**Marist Catholic College North Shore (SSD-10473)
Response to Submissions**

ATTACHMENT 1

Drawing No. DA-231	Issue A
Scale 1 : 100	Drawing Size A1
Project No. 18165	Drawn By BE

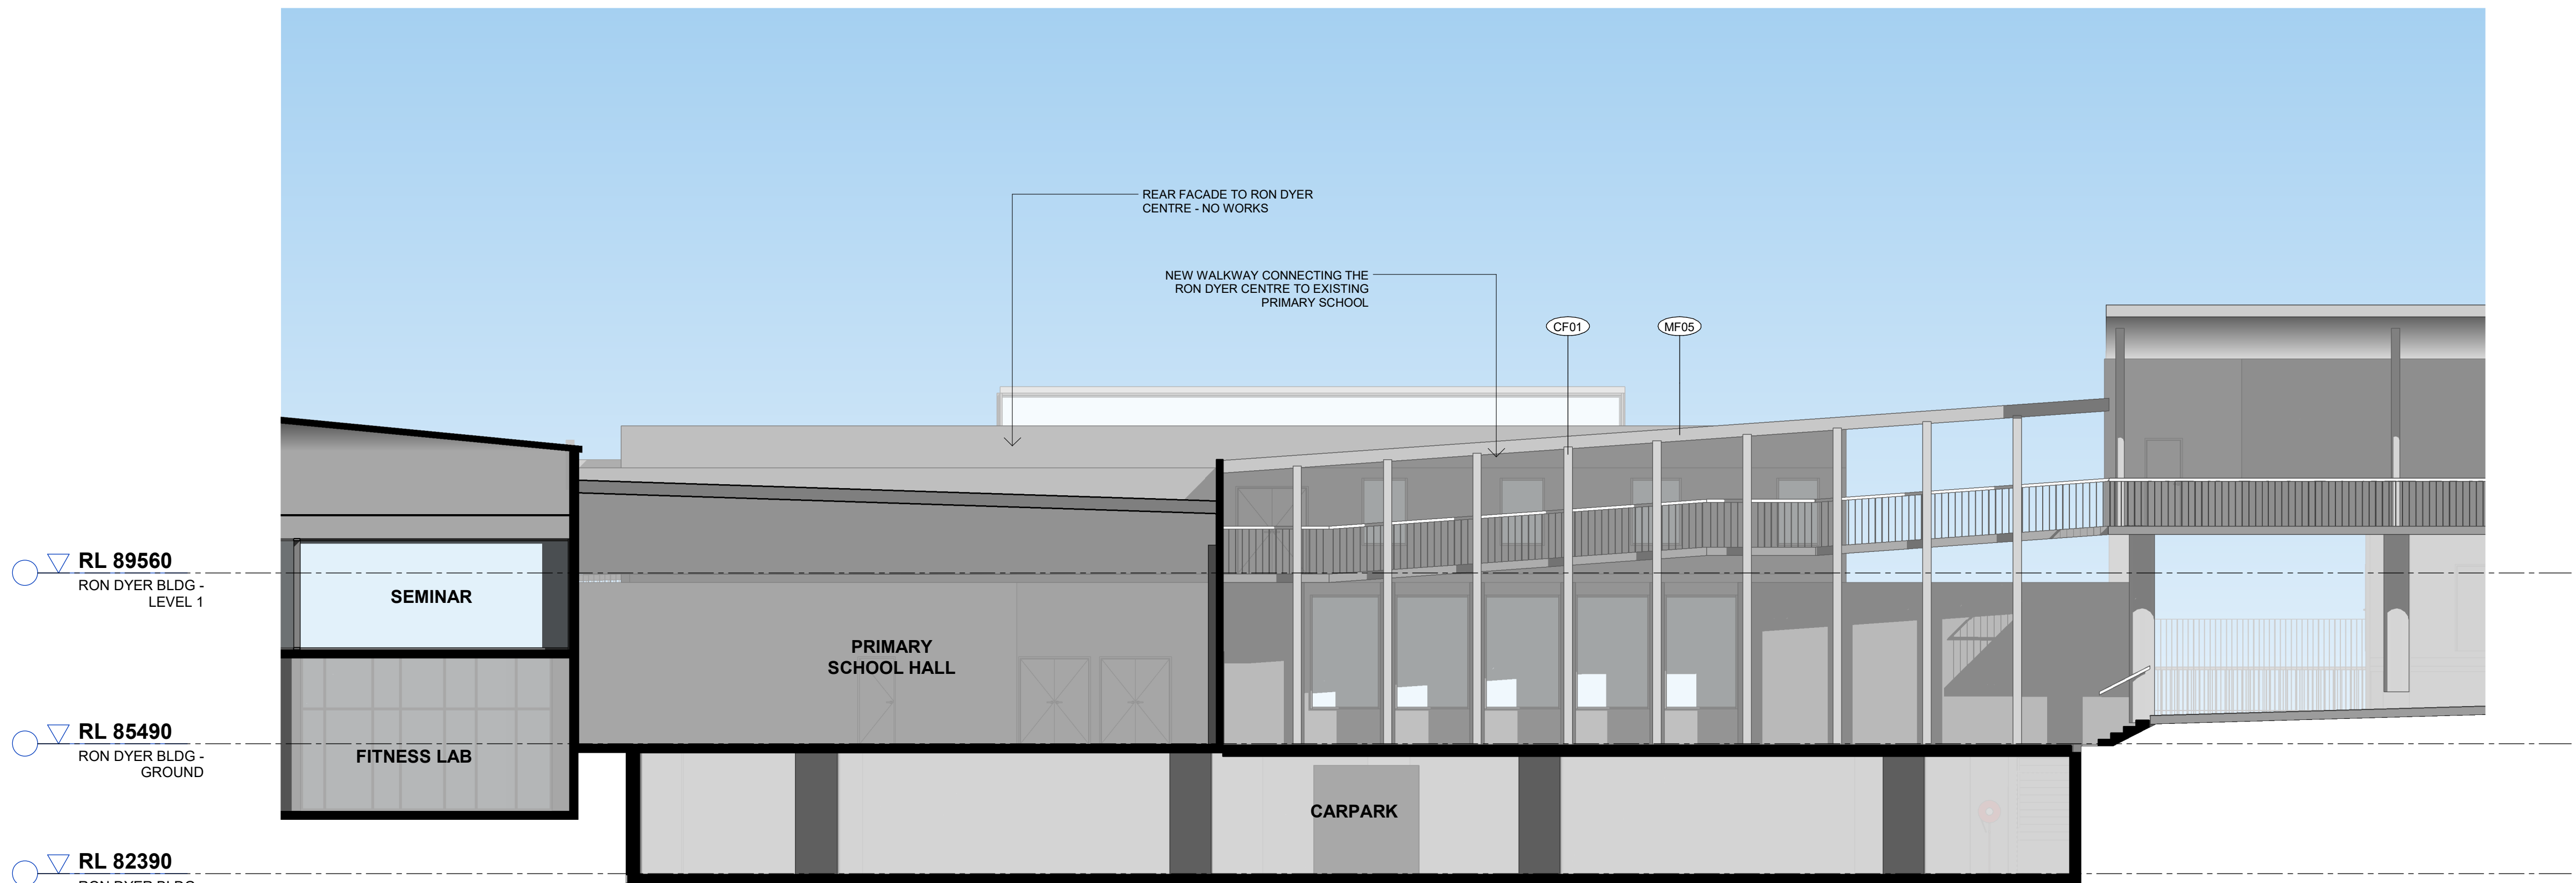
- correctly show the 6 parking spaces adjacent to St Mary's Church as accessible spaces (currently shown as 7 standard parking spaces).
- include elevational / sectional drawings showing the amendments to the Ron Dyer Centre and Presbytery and the proposed 2 storey pavilion building.
- include new and updated computer generate imagery (CGIs) including:
 - new CGI imagery taken from within the site to demonstrate the proposed changes - particularly showing the new courtyard north of the Church,
